CITY OF ALBUQUERQUE

March 12, 2025

**Re: West Mesa Ridge
Traffic Impact Study(J11D048)**
Engineer's Stamp 2-25-25
Via email: clay.koontz@stantec.com and ABQ-PLAN

The subject Traffic Impact Study (Study) draft received on February 25, 2025 , has been reviewed by the City of Albuquerque Planning Development Transportation Section and provides the following comments.

TCL1.0

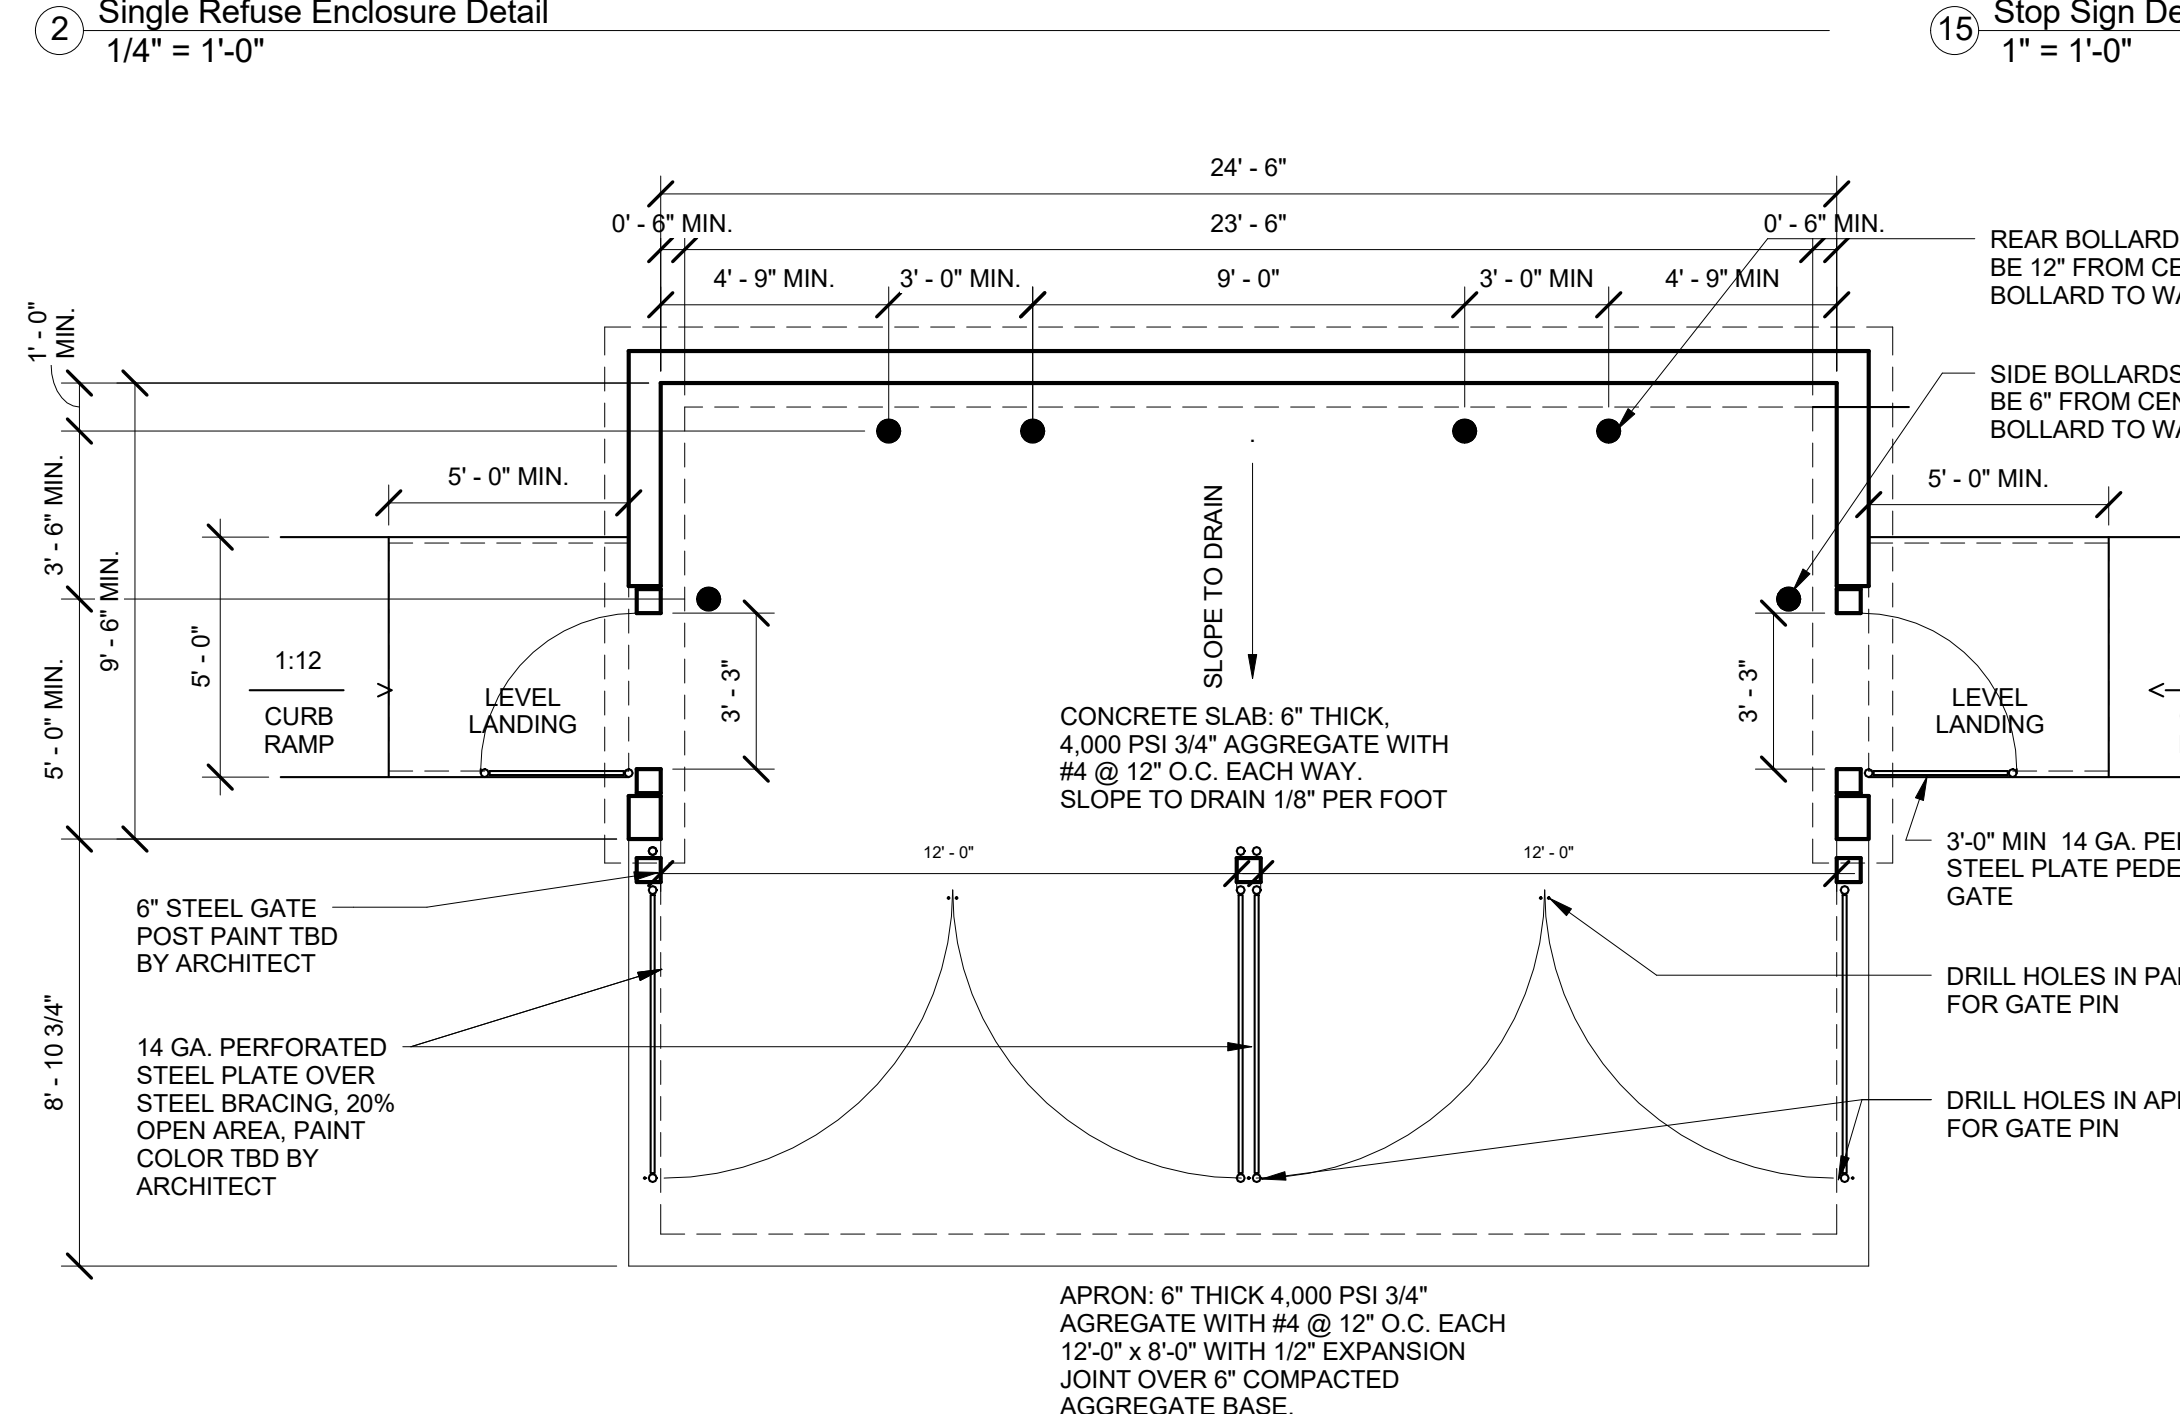
- b. Adding a crosswalk and signage should improve pedestrian safety at 64th and Fortuna Rd.
 - c. The walking distance across the Fortuna Rd entrance should be shorter or include a pedestrian refuge.

- d. Reduce radii at all entrances to 15'. This will shorten pedestrian paths and may require a slow drivers.
